**RE: Buddhist Temple
Grading and Drainage Plan
Engineer's Stamp Date 1-25-17 (File: K17D112)**

RE: **Buddhist Temple**
Grading and Drainage Plan
Engineer's Stamp Date 11-11-16 (File: K17D112)

Re: Wat Buddhocothorn-Vibes Buddhist Temple
139 Madison St NE
Traffic Circulation Layout
Architect's Stamp dated 07-27-16 (K17D112)

C-101

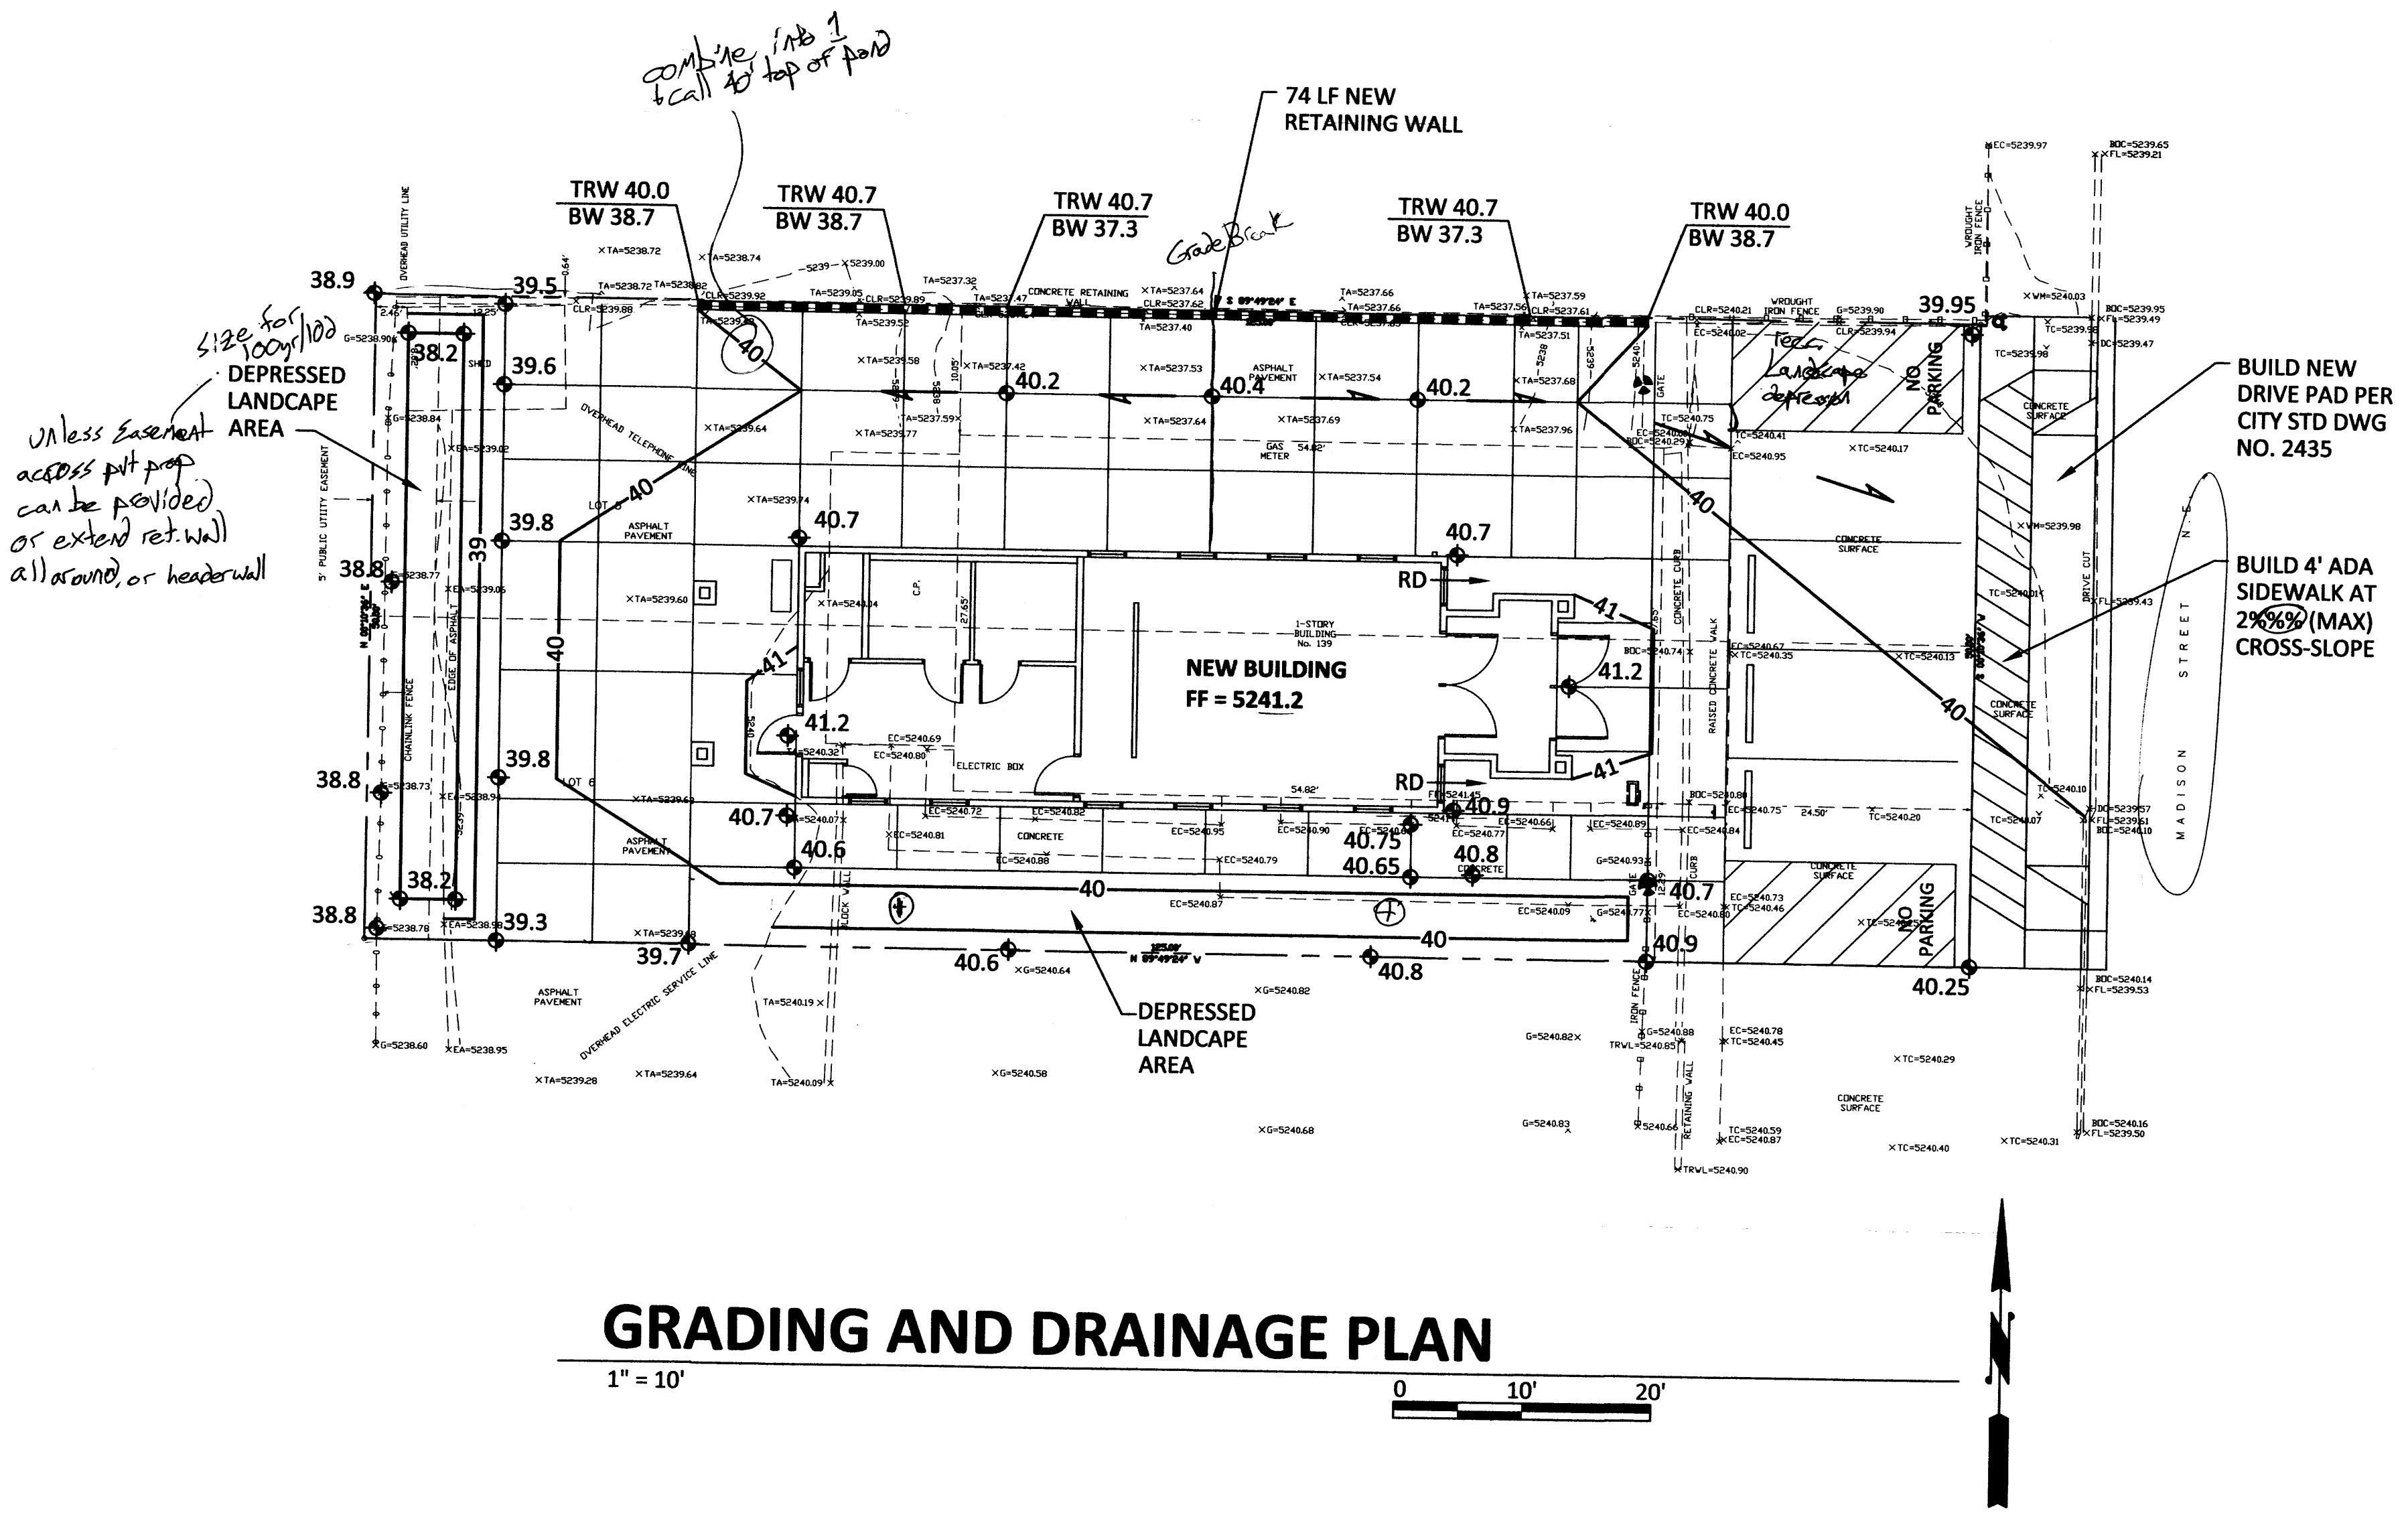
1. The Drainage Approach currently states that all flows are to be conveyed *west* to the existing drive pad. The only existing drive pad is to the *east* on Madison Street, is this the referred to drivepad?

2. As shown on the drawing, a north-south grade break roughly bisects the lot, sending some flow east towards Madison Street and some flow west towards the back of the lot. The area flowing toward the back of lot will need to be detained on-site for the 100-year, 10-day storm event. Several measures are recommended to accomplish this:

- a. A short (approximately 18" high) header wall may be placed along the back of the lot and waterproofed in order to raise the ponding depth to 5240'. This will increase ponding area and depth, while remaining at least one foot below the finished grade of the slab.

- b. The proposed depressed landscape areas may be widened, deepened and combined into one to contain a greater volume.

Supporting calculations would be needed if an above option is selected. Options that would not require detaining the 100-year, 10 day storm include:

- a. Regrading the lot to convey all flows towards Madison Street. This will likely require raising the finished grade of the building slab.
- b. A private drainage easement with the adjoining lot may be negotiated to convey flows to either Copper Avenue or Jefferson Street.

1. Provide finished grade spot elevations for bottom of depressed landscape areas.

2. Correct build note "...2%%% (max) cross-slope."
3. 4x font on "Madison Street" label

Although not required, the areas labelled "no parking" may be left as crusher-fines or converted to landscaping with westward flows routed through them to decrease impervious area. If you have any questions, please contact me at 924-3695 or dpeterson@cabq.gov.

1. The drainage approach has been corrected to refer to the drivepad on the east side of the site.
2. The proposed ponding area on the west side of the site has been revised to retain the 10-day storm volume as required. Calculations reflect this change.
3. The three minor edits noted have also been addressed.

A1 TRAFFIC CIRCULATION LAYOUT

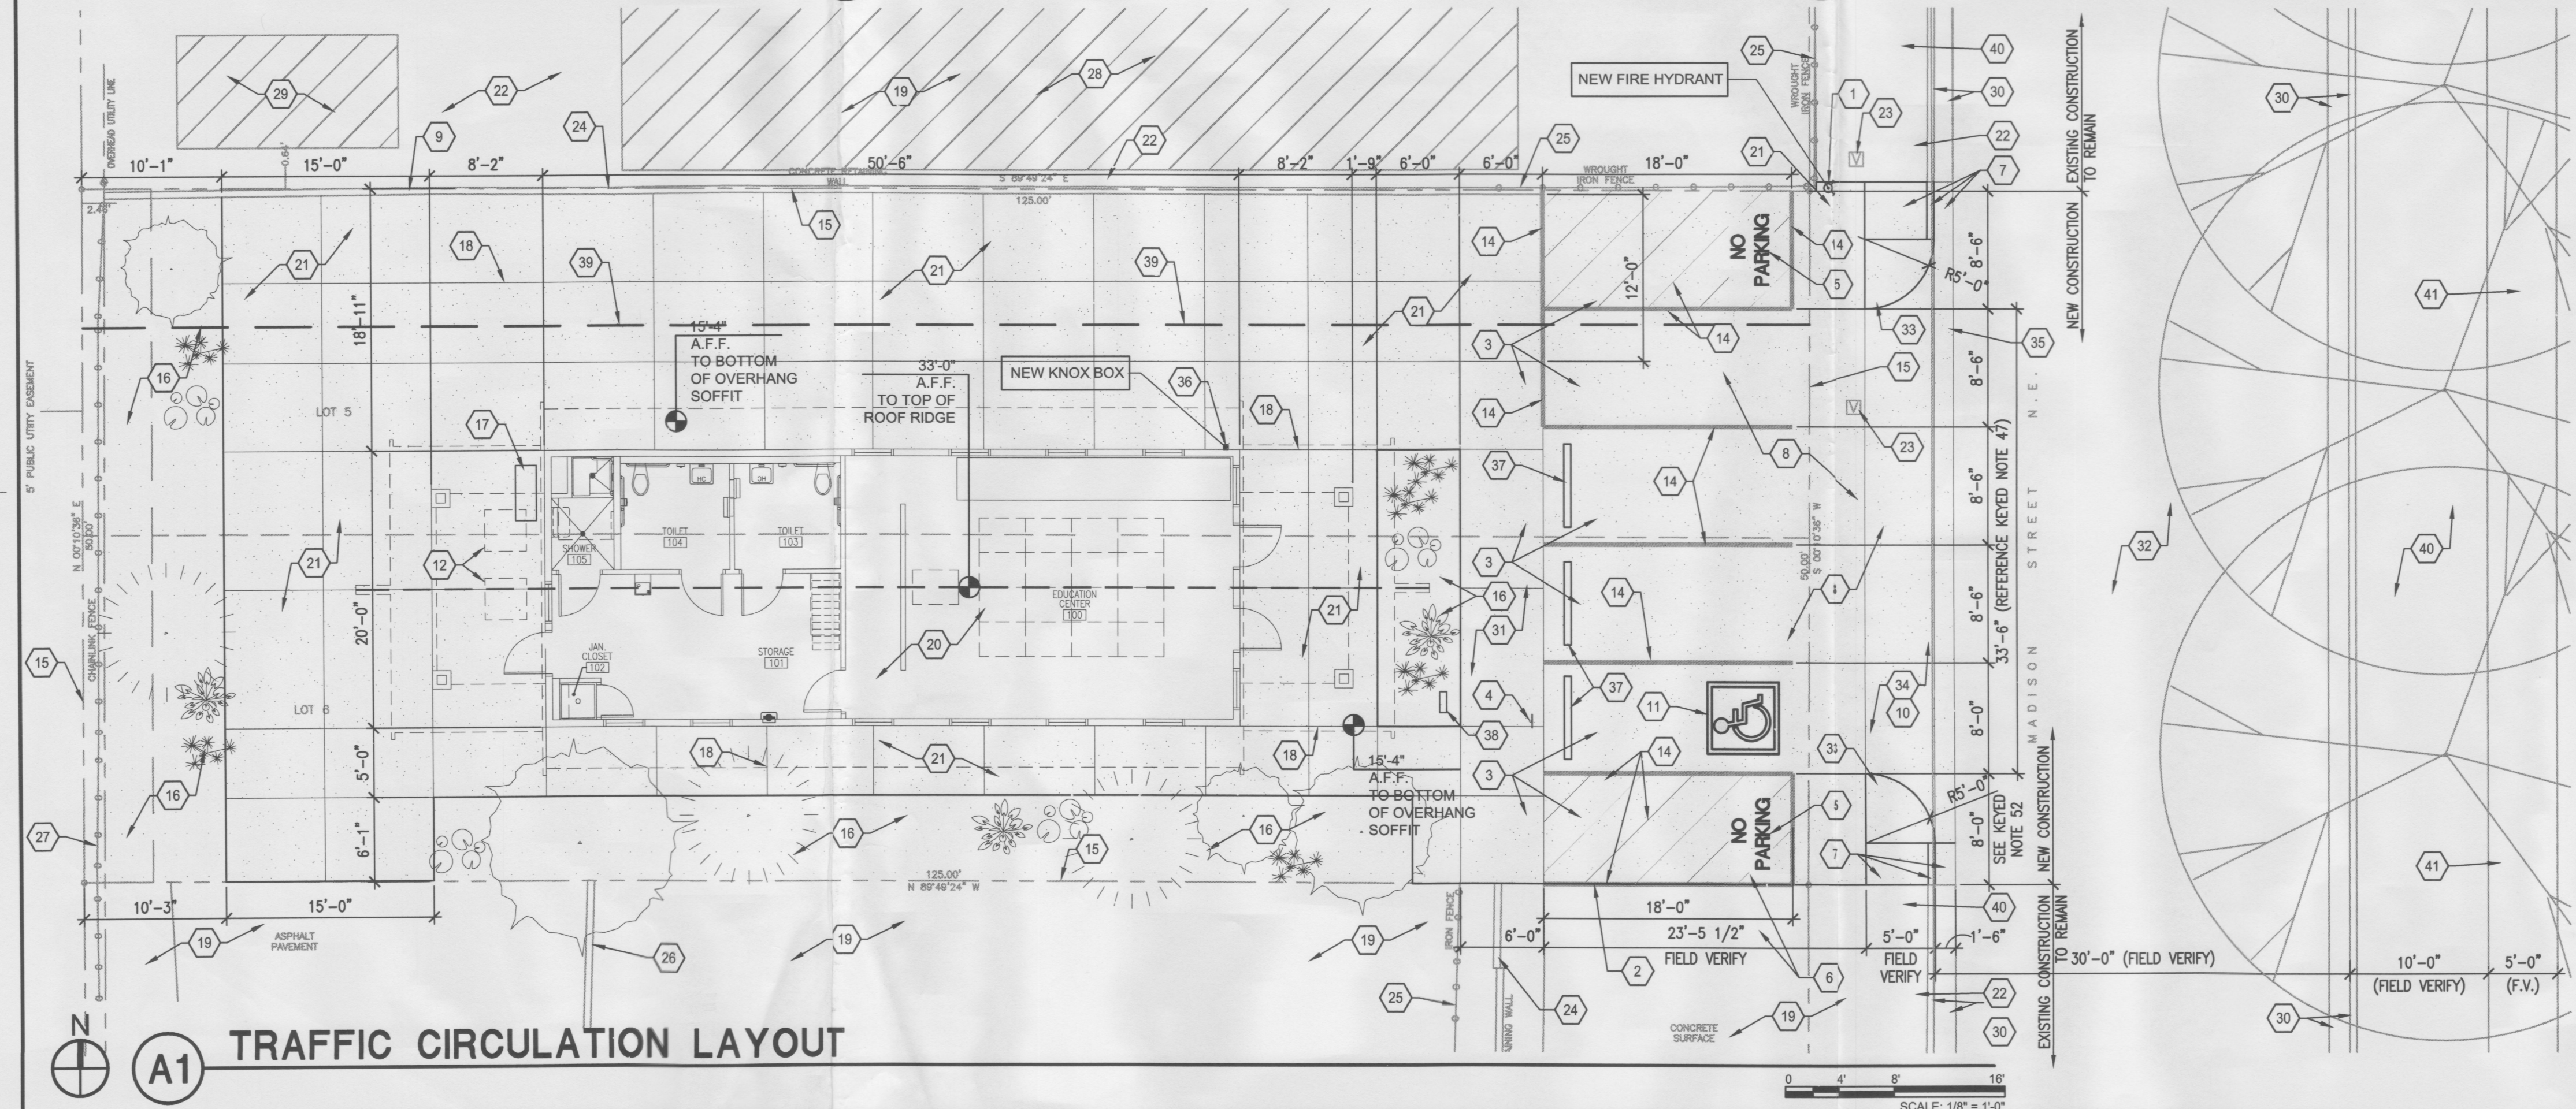
1. The ADA accessible parking sign must have the required language per 66-7-352.4C NMSA 1978 **"Violators Are Subject to a Fine and/or Towing."** Please call out detail and location of HC signs.
2. The ADA access aisles shall have the words **"NO PARKING"** in capital letters, each of which shall be at least one foot high and at least two inches wide, placed at the rear of the parking space so as to be close to where an adjacent vehicle's rear tire would be placed. (66-1-4.1.B NMSA 1978)
